MORTDALE RESOURCE RECOVERY FACILITY

05 APRIL 2019

BINGO INDUSTRIES PTY LTD MORTDALE RESOURCE RECOVERY FACILITY

Response to Submissions

Figure 6.1: Utilisation of Stacking Spaces – Typical Operation

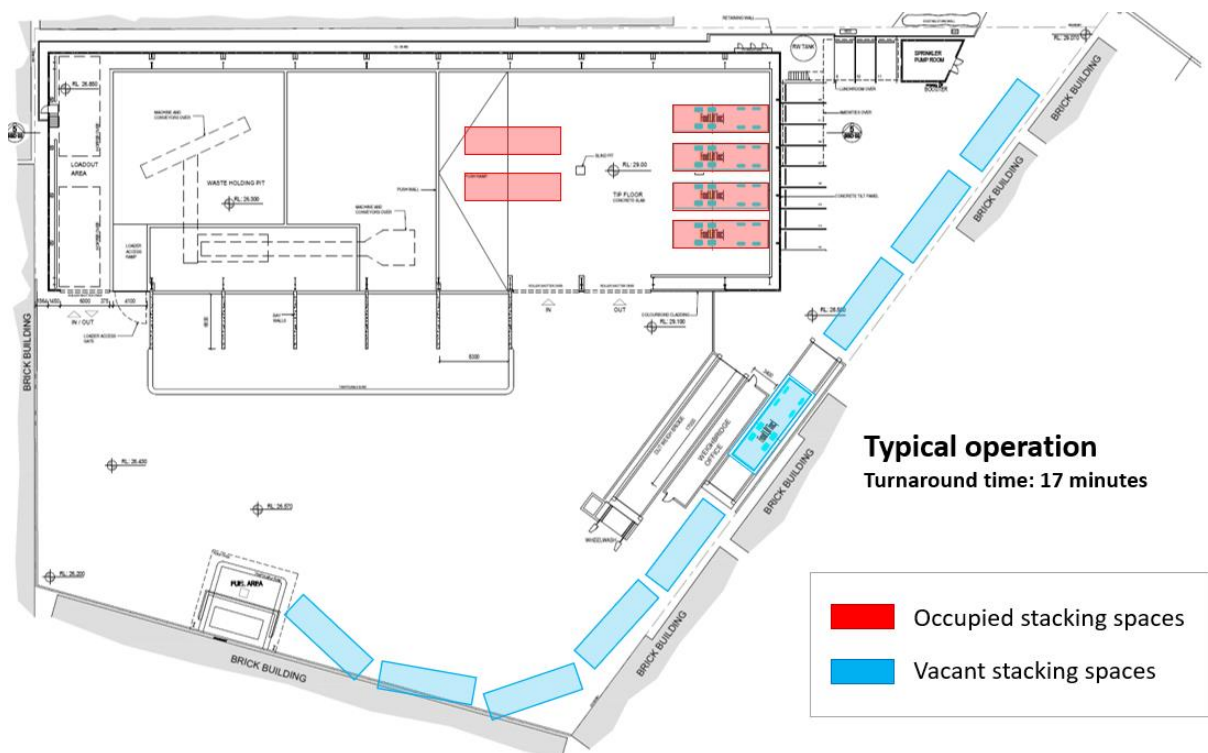
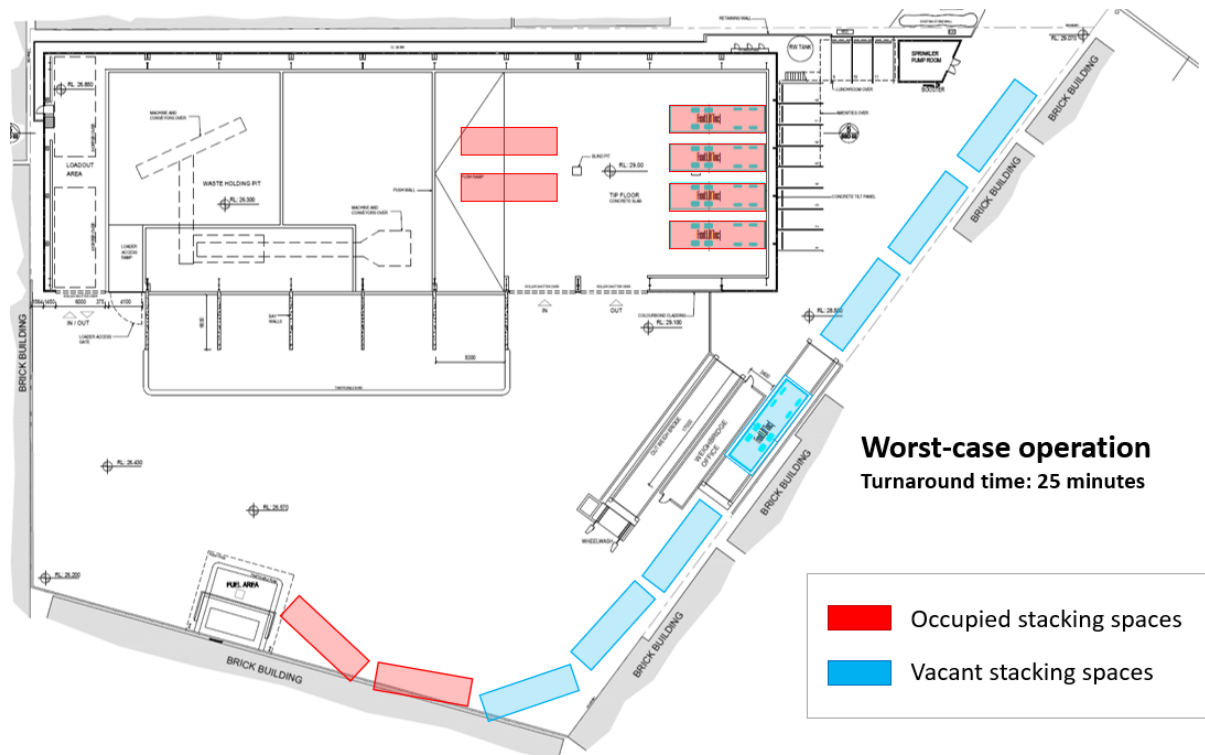
<p>f. Please show how the number of trucks (deliveries and collections) in the busiest hour would be able to access the site under worst case scenario without queuing on the local road network, this should include how swept paths will be maintained and trucks can exits the site if trucks are using stacking spaces under normal and worst case scenarios.</p>	<p>A summary of on-site stacking including an assessment of the typical and worst-case scenarios has been included in section 6.8.2 of the Modification Report and is detailed in the Amended Traffic Impact Assessment (Appendix E of the Modification Report). Figure 6-3 shows that even under the worst-case scenario in the busiest hour, the 18 trucks would be adequately accommodated across 8 stacking spaces, leaving seven stacking spaces remaining which could accommodate a potential overflow of vehicles in the event of an incident occurring.</p> <p>In all scenarios shown (typical and worst case) there are vacant stacking spaces available within the stacking channel and on-site stacking would extend beyond the weighbridge office that is on-site. Therefore, in the busiest hour, all trucks predicted to arrive at the site would be accommodated wholly on-site and would not be required to queue onto the local road network.</p> <p>Stacking spaces have been positioned outside of the path of travel for all vehicles entering and exiting to enable vehicles to manoeuvre safely around the site even during peak periods. Updated swept paths have been provided in Appendix A of this document to also show stacking spaces.</p>	<p>Section 6.8.2 of the Modification Report Appendix E of the Modification Report</p>

DWG No.	16222CAD007
FIGURE 2	
DATE STAMP	22 FEBRUARY 2019
PROJECT No.	16222
SCALE	1:400 @ A3
REV.	A

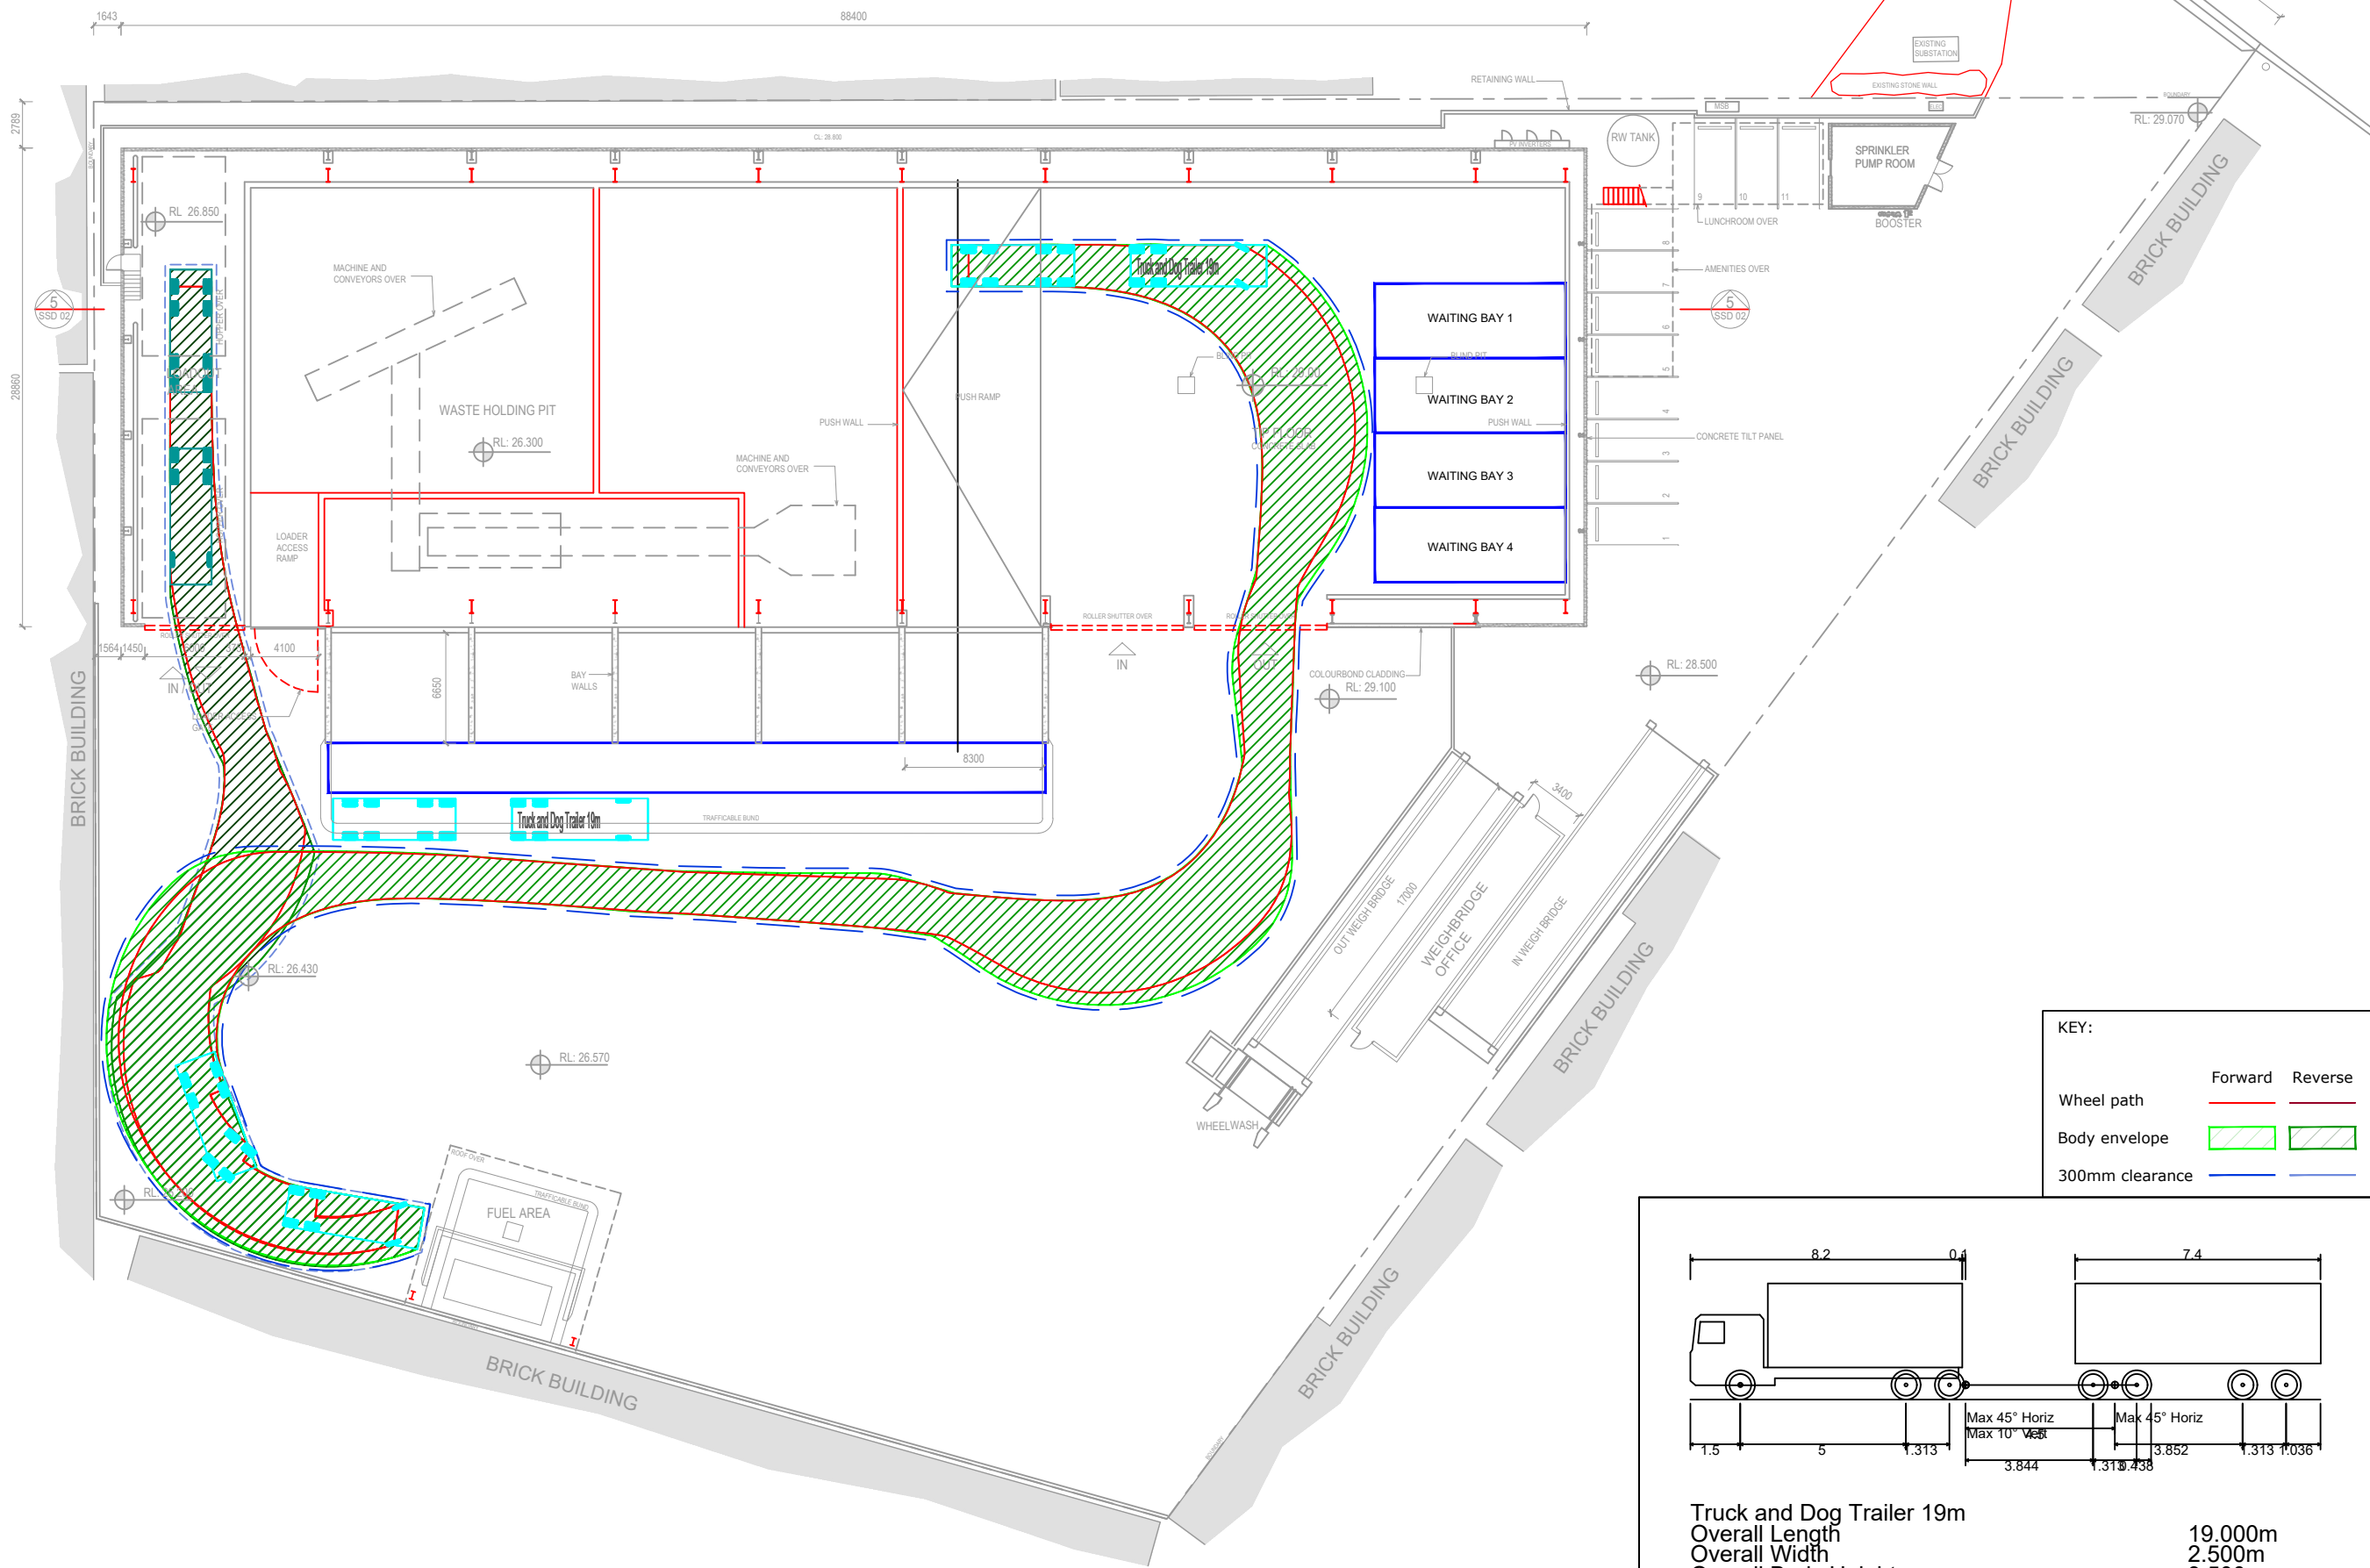
<p>g. Please clarify whether vehicles will be reversing or driving into the bunker area or both (p.44).</p>	<p>Normal operations would require vehicles to reverse into the bunker area. Swept paths have been included in Appendix E of the Modification Report (Amended Traffic Impact Assessment) and</p>	<p>Appendix E of the Modification Report</p>

Submission text	Response	Reference
	updated in this document (Appendix A of this document). These swept paths demonstrate that the reverse in manoeuvre can be undertaken safely.	Appendix A of this document
Air Quality: a. Clarify whether Table 6-2 includes the reduction in air emissions from material sorting as set out in the proposed modification. Provide source for figures in Table 6-2 (NB this table does not appear to be in Appendix D).	<p>The estimated annual emission rates for the Modification Proposal, as presented in Table 6-2 of the Modification Report include reductions in air emissions from material sorting and reduced throughput (compared to the 300,000 proposed within the original EIS).</p> <p>It is noted that a superseded version of the Air Quality Assessment (prepared by Wilkinson Murray) was erroneously appended to the Modification Report. The correct version of the Air Quality Assessment has been included as Appendix B of this document. This version includes further detail on the emissions rate and control factors relating to information summarised in Table 6-2.</p>	Appendix B of this document
